Your Ref: OWPC17974
Our Ref: AB/26/18/L
Please ask for:
Mr A Wood

Planning (Listed Buildings and Conservation Areas) Act 1990 (as amended)

Listed building consent for replacement of the existing external signage scheme
The Swan Hotel 27-29 High Street Arundel

PROPOSED ELEVATIONS

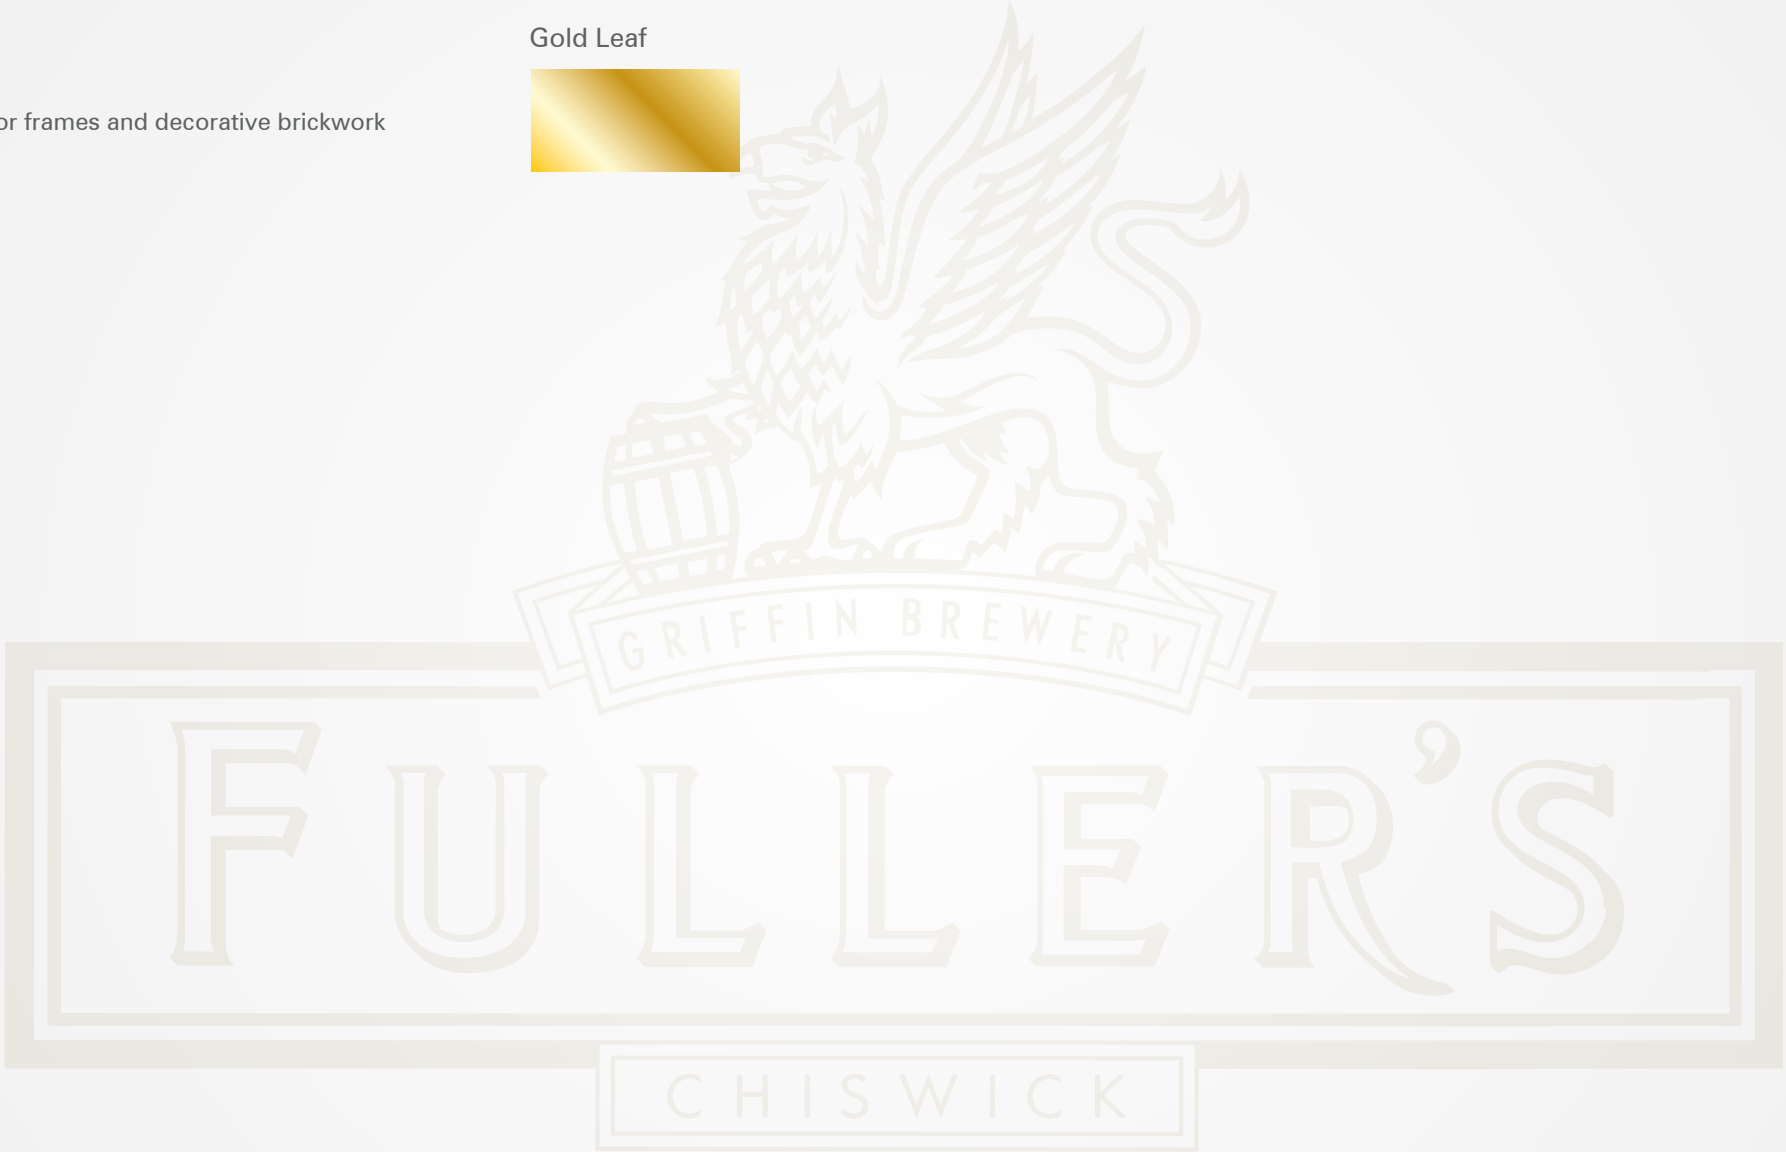
The Committee considered that the additional illumination would result in excessive light spillage that would detract from the character and appearance of this part of the Conservation Area.
